To: A303 Sparkford to Ilchester Dualling Scheme
National Infrastructure Planning

From: Sarah Bucks, for and on behalf of the South Somerset Bridleways Association
(reference 20015184)

Re: response to the letter sent 5th. November to Highways England and all interested parties, reference TR010036-001538.

Date: 23rd. November 2019

Figure 2.8: Changes to highways in the vicinity of Hazlegrove Junction

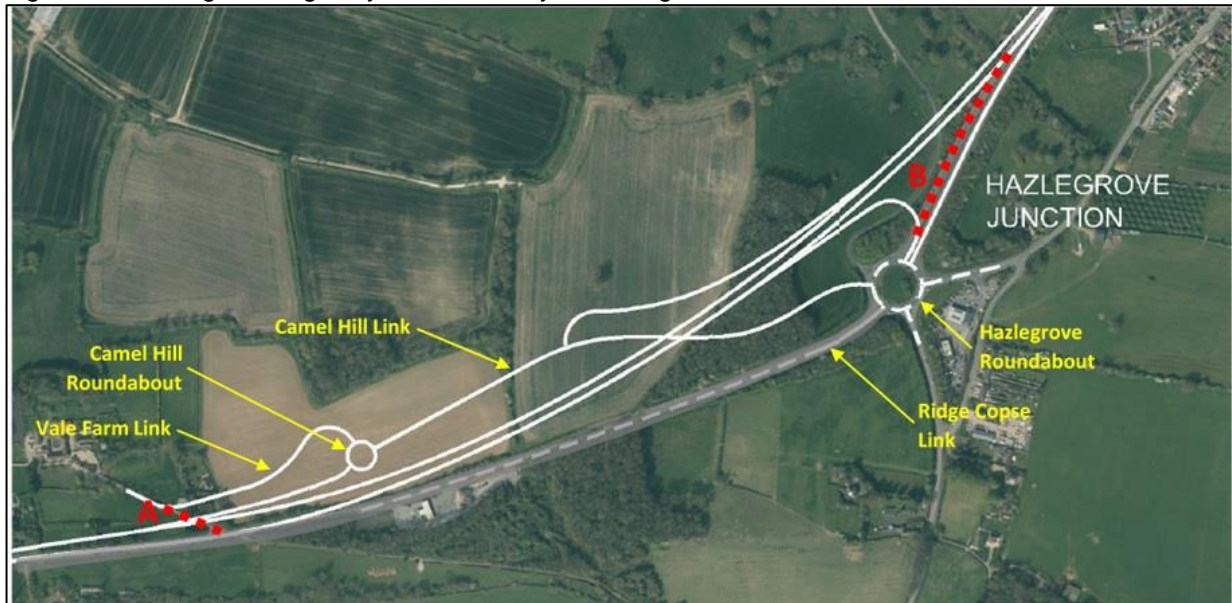
As the scheme is currently designed, the only route for horses kept at Camel Hill to be ridden out is through the tunnel and then around the Hazlegrove roundabout with the traffic and across the A303 off ramps.

Another concern is that by designating footways and cycleways, equestrians are going to be excluded on routes which they can currently use. A particular example is the verge around the southern section of the Hazlegrove roundabout. Currently equestrians can use this wide section of grass in both directions. By making it a footway and cycleway, equestrians will be forced onto the vehicular carriageway, and have to ride or drive around the roundabout and across the new A303 off ramps. If the verge was dedicated as a restricted byway, and it is certainly wide enough, equestrians could travel in both directions, off the carriageways carrying motorised traffic.

Figure 2.11: Proposed non-motorised user routes (west

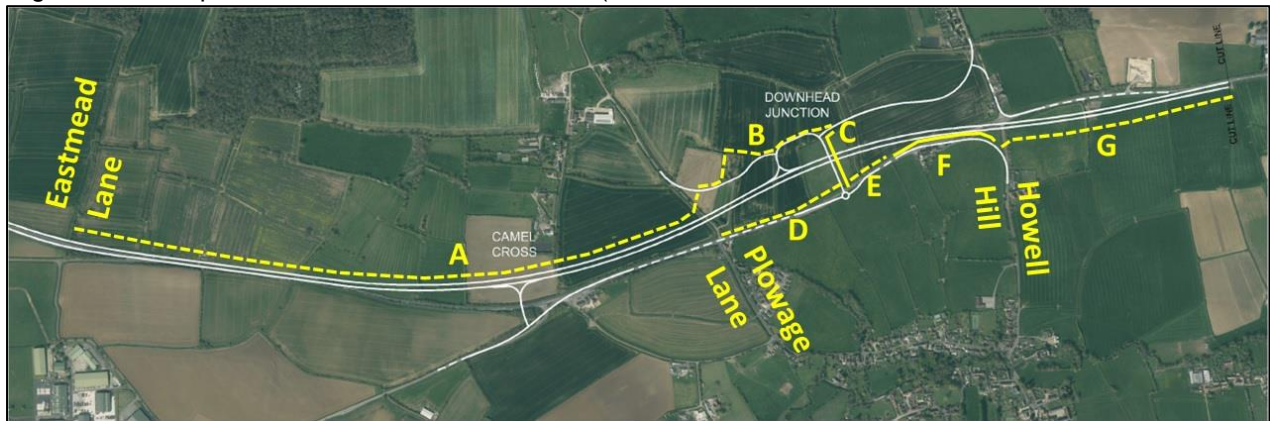
Throughout the consultation stage earlier in 2019, discussions and plans included the provision of NMU routes to provide off road alternatives to the dual carriageways, mitigate the severance of routes, and enhance the existing rights of way network, which includes restricted byways and bridleways. On the day of the final consultation it was indicated that NMU routes would only have bridleway status, and no provision would be made for carriage drivers. Carriage drivers, arguably the most vulnerable road users, will have nowhere to drive except the new carriageways. Their very limited network of restricted byways will be fragmented. Very few will dare to use the new carriageways, and if they do there could be some horrific accidents. If the scheme is making provision for non-motorised users, it should be for all such groups, and not give a legal status which omits some equestrians. These NMU routes are new build, and we can see no reason why they should not be to restricted byway standard and status. If considered necessary, furniture such as height restrictors or bollards could be specified to deter illegal use by motorised vehicles. Where are the carriage drivers, rate payers like everyone else, expected to go?

If these new NMU routes were to be designated as restricted byways, then all vulnerable non-motorised road users could avail themselves of them. Surely as newly constructed tracks, they should carry the appropriate status of restricted byway. Excluding carriage drivers from the NMU routes is not good for equestrians, nor for motorists who will not expect to see them on carriageways designed and built to 'Expressway' standards.

Fragmented network Our hope is that this project will take the opportunity to ensure there are linking and through routes so that equestrians can travel from community to community, and hopefully create a network to make circular routes. Thus the connection between Eastmead Lane and Podimore, the link between Slate Lane and the public road at Camel Hill, and the link between the northern end of Gason Lane and Traits Lane are all vital to create a network.
